**7000acres Comments on the Applicant's Aerial Flyover Footage using Google Earth Data – dated 6 February 2024**

**Reference:** Deadline 4 Submission - C8.2.12 Aerial Flyover Footage using Google Earth Data (Low Resolution) (Video, 111MB)

**Deadline 5 – February 2024**

Figure 8.14.76b

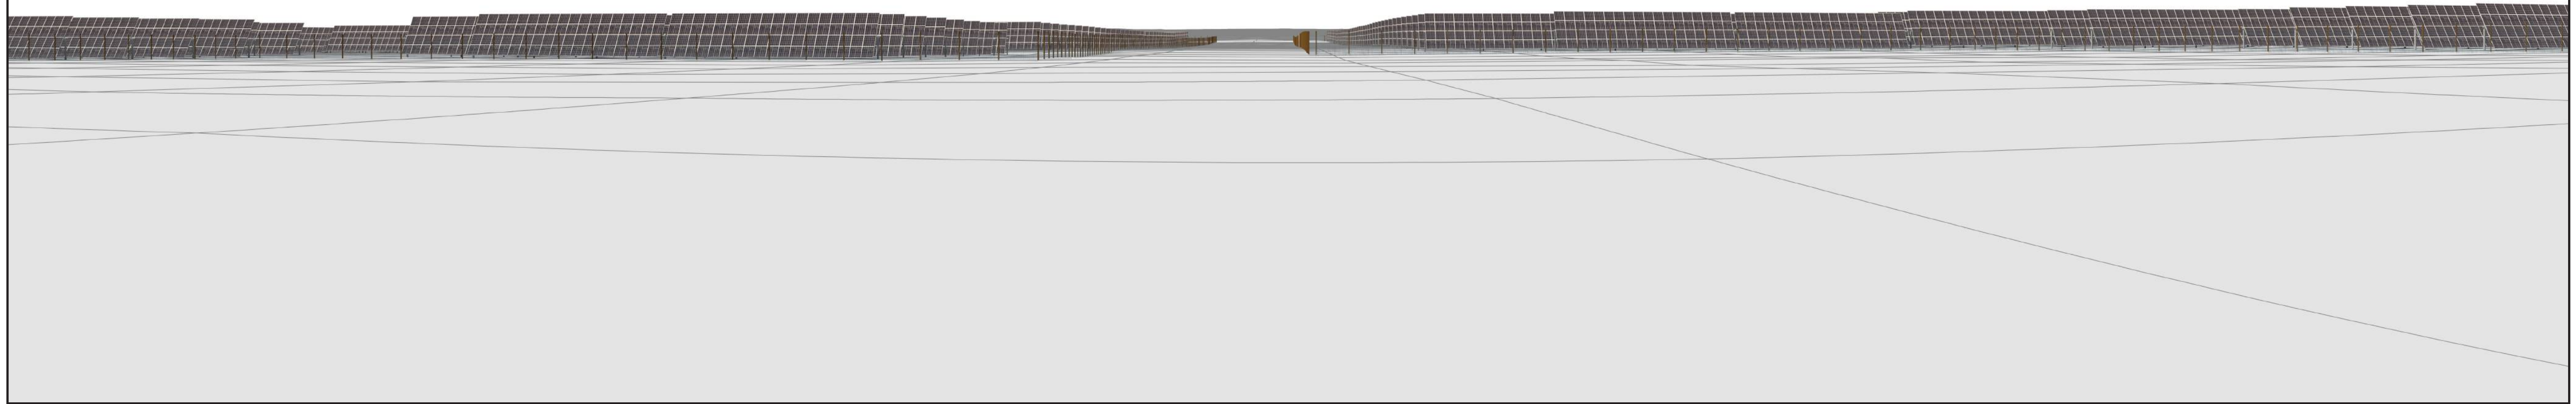
When the photomontages provided by the Applicant are verified, some very concerning errors become apparent. The image below is from the Applicant’s submission - C6.4.8.14.76 Figure 8.14.76 LCC-C-I Viewpoint 76 Photography Photomontage. This photomontage allegedly shows 4.5 metre high sun tracking solar panels, facing east. What is actually shown appears to be 3.5m panels.

A representative of 7000Acres used a 4.5m long pole to compare the alleged height of the solar panels in the photomontage to the real world. It can be clearly seen that the 4.5m high pole extends above panels shown in the photomontage.

Furthermore, the viewing point chosen is not representative of an upright average size human, but the viewpoint of a medium sized dog. A typical local hedge is circa 2m high, and many of the Applicant's viewpoints have been photographed from half way up the hedge, where the Applicant's representative must have been kneeling or sitting.

Additionally, the fencing shown on the left hand side of the photomontage appears to use wooden fence posts, with no fencing, CCTV or lighting structures in place.
